DWR # 20250885
Alamance County

Subject: REQUEST FOR ADDITIONAL INFORMATION
NCDOT – proposed replacement of Bridge No 14 located on NC 87 over Cane Creek
Eli Whitney, Alamance County. NCDOT TIP: BR-0060

On July 7, 2025 the Division of Water Resources (Division) received your application requesting a 401 Water Quality Certification and Buffer Approval from the Division for the subject project. On July 22, 2025, additional information was requested via email for the project. At this time, the Division has determined that your application is incomplete and cannot be processed. **The application is on-hold until all of the following information is received:**

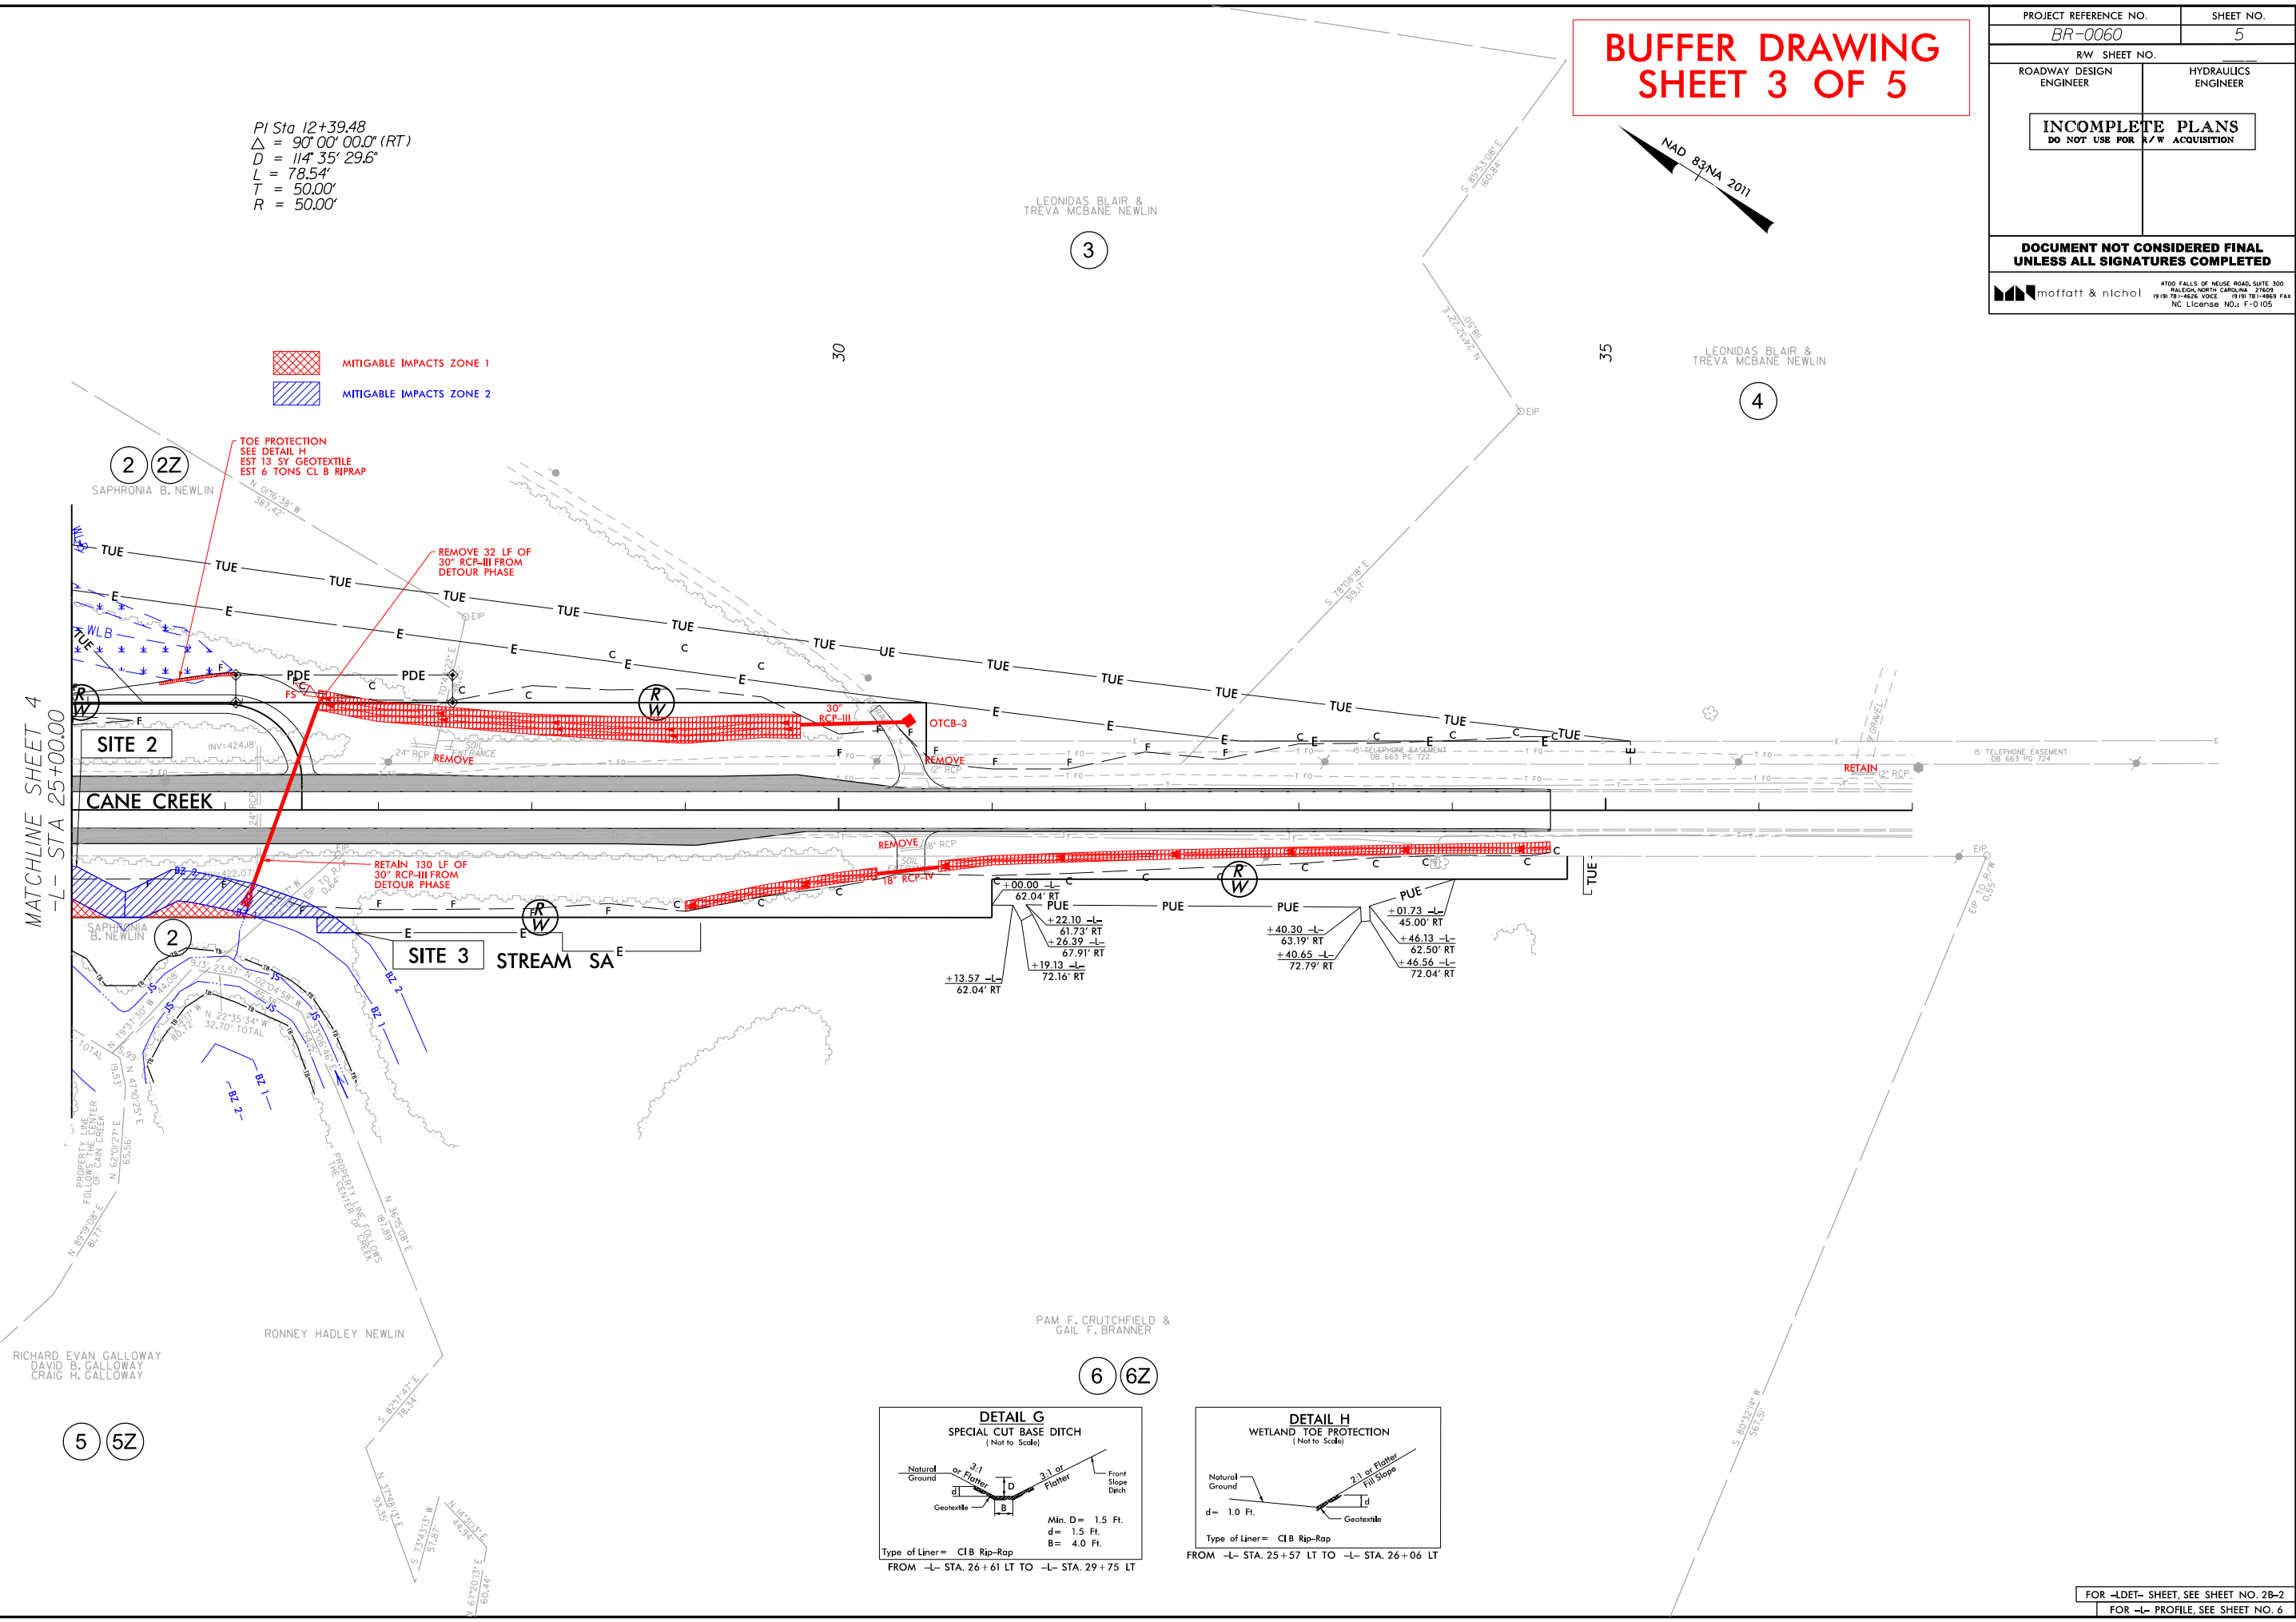
1. Confirm Sheet 5 of the Permit drawings. At the end of the Project and east of NC 87, there is an off-site pond which appears to drain into the Project area. Please provide supporting information and data forms collected in this area.
2. Based on the Jurisdictional Features Map, stream SB and SC are located on-site.
3. Provide a topographic map and soil survey of the revised Project area.
4. Please label stream SB and Stream SC throughout the permit and buffer drawings.
5. Please provide the Stream ID forms collected for stream SB and SC.
6. Stream SC does not appear to be depicted on the permit drawings.
